Item No. **Report of the Head of Planning, Transportation and Regeneration**

Address 137 LONG LANE HILLINGDON

Development: Installation of vehicular crossover to front.

LBH Ref Nos: **46529/APP/2020/3909**

tpo 157

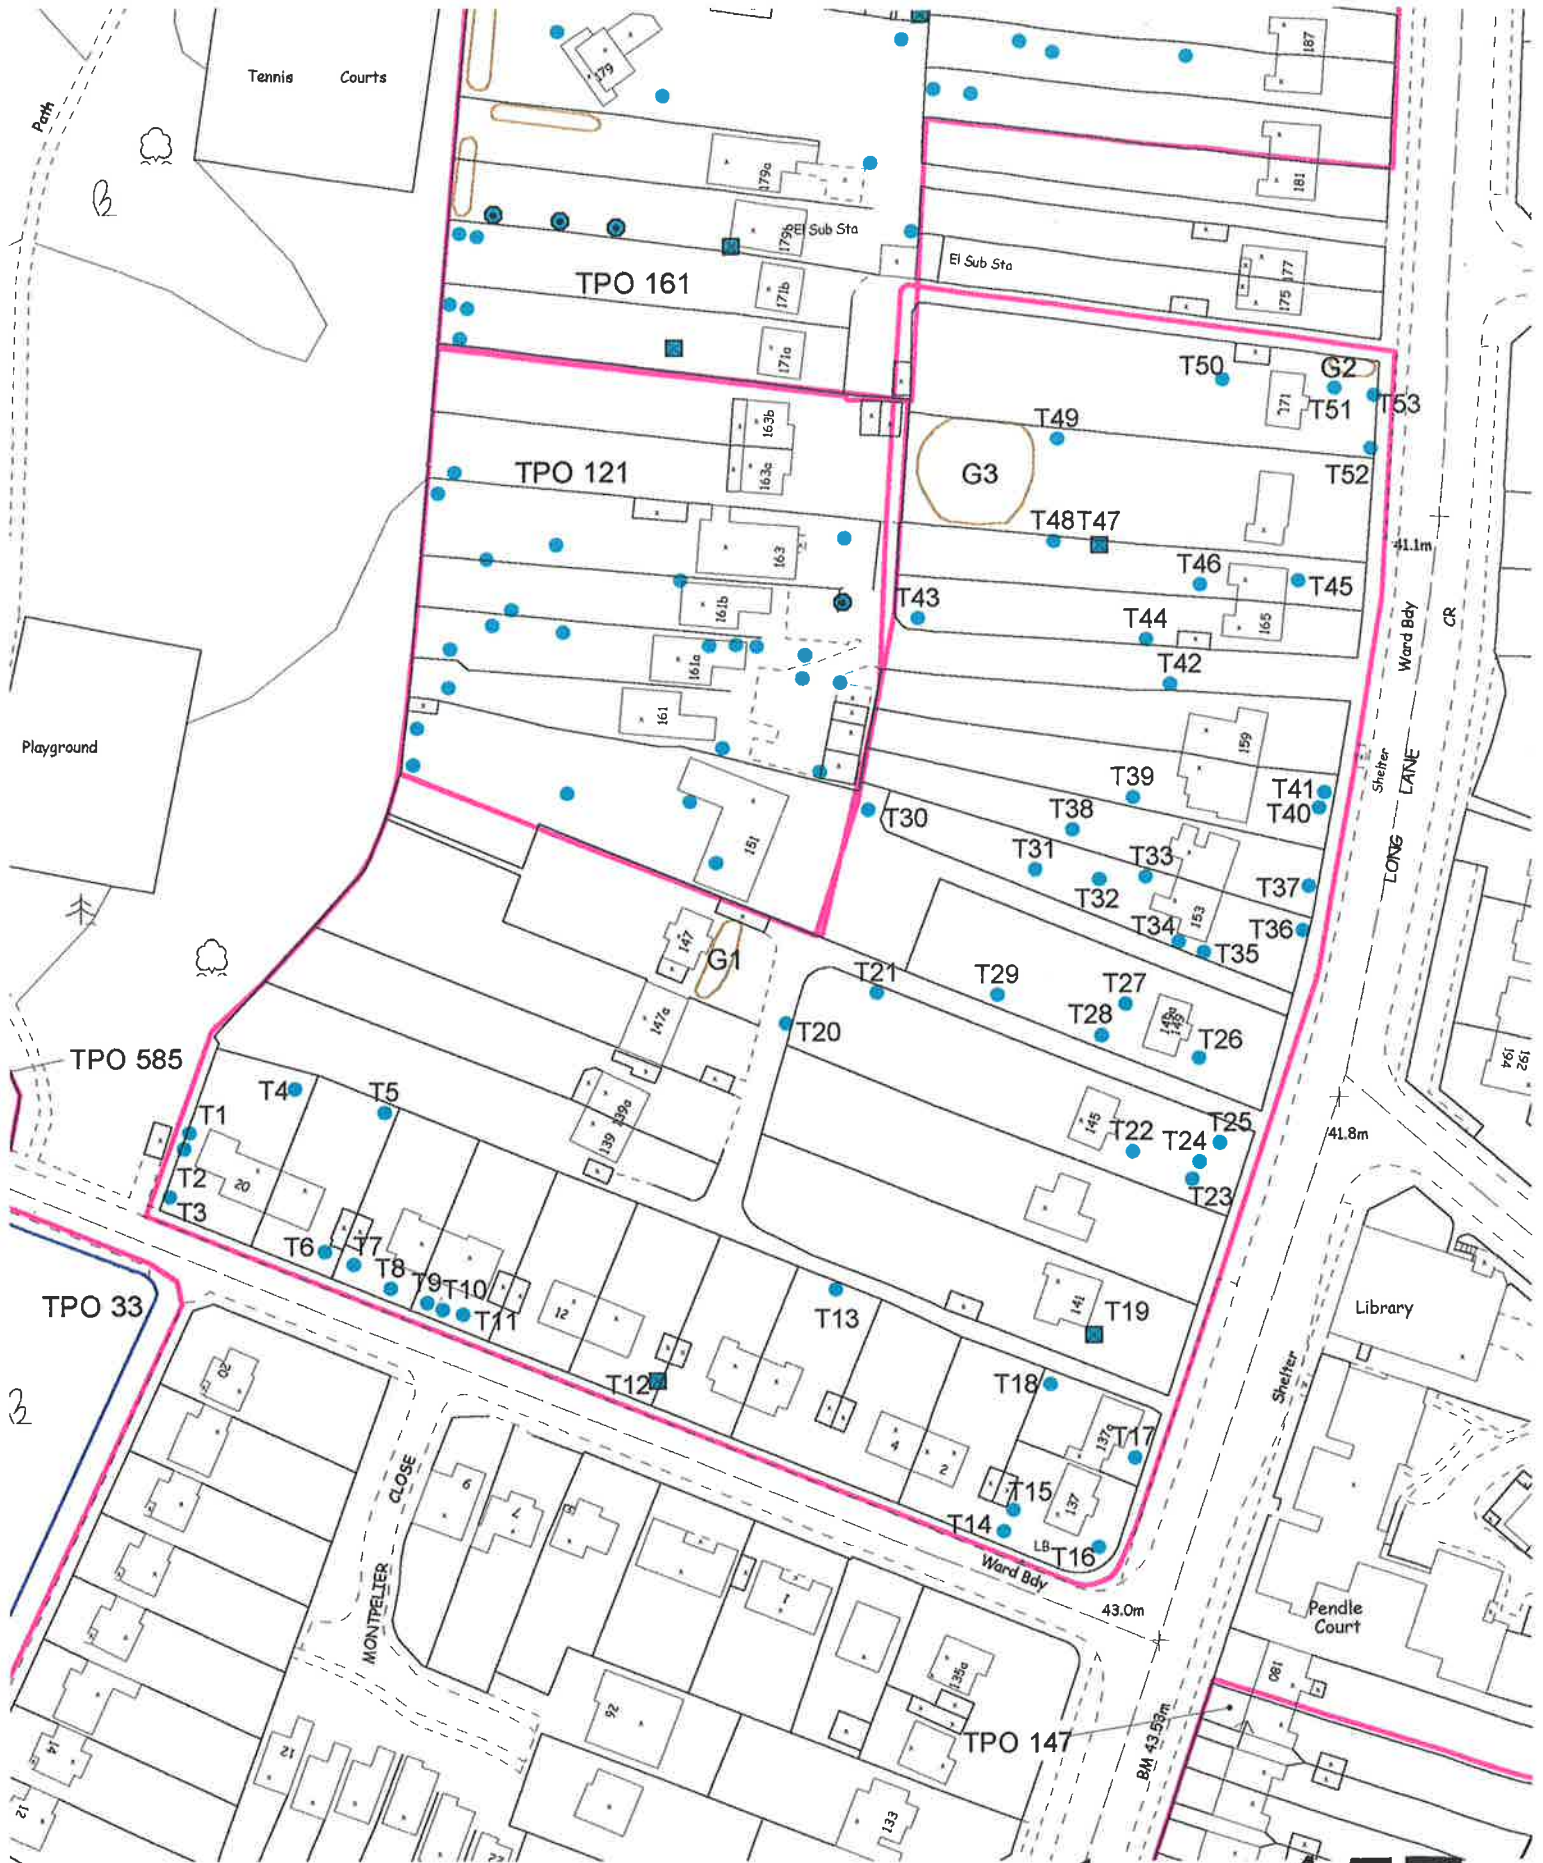
The site lies within the area covered by TPO 157 and there are several protected trees at this address including T16 a mature oak situated in the front garden (south-east corner). -

According to the completed planning questionnaire (Q.9) there are no trees on the site? COMMENT No trees will be affected by the proposed vehicular cross-over (the subject of this application), however, the construction of the driveway is unacceptable without further supporting information. The proposed driveway may well be within the RPA (root protection area) of the protected oak. A tree report will be required to check whether, and how, the driveway can be constructed without affecting the protected tree. RECOMMENDATION Clarification is required about the protected oak (T16) and the construction of the driveway - without which it would be unsafe (and pointless) constructing the vehicle crossover.

The Council's Landscape Officer has advised that the construction of the driveway is unacceptable without further supporting information. The proposed driveway may well be within the RPA (root protection area) of the protected oak. In the absence of a Tree Survey and Arboricultural Implication Assessment to BS5837: 2005 standards, the

application has failed to demonstrate that the development will safeguard existing trees on the site and further fails to demonstrate protection for long-term retention of the trees. The proposal is therefore contrary to DMHB14 and DMHB11 of the Hillingdon Local plan - Part Two (2020).
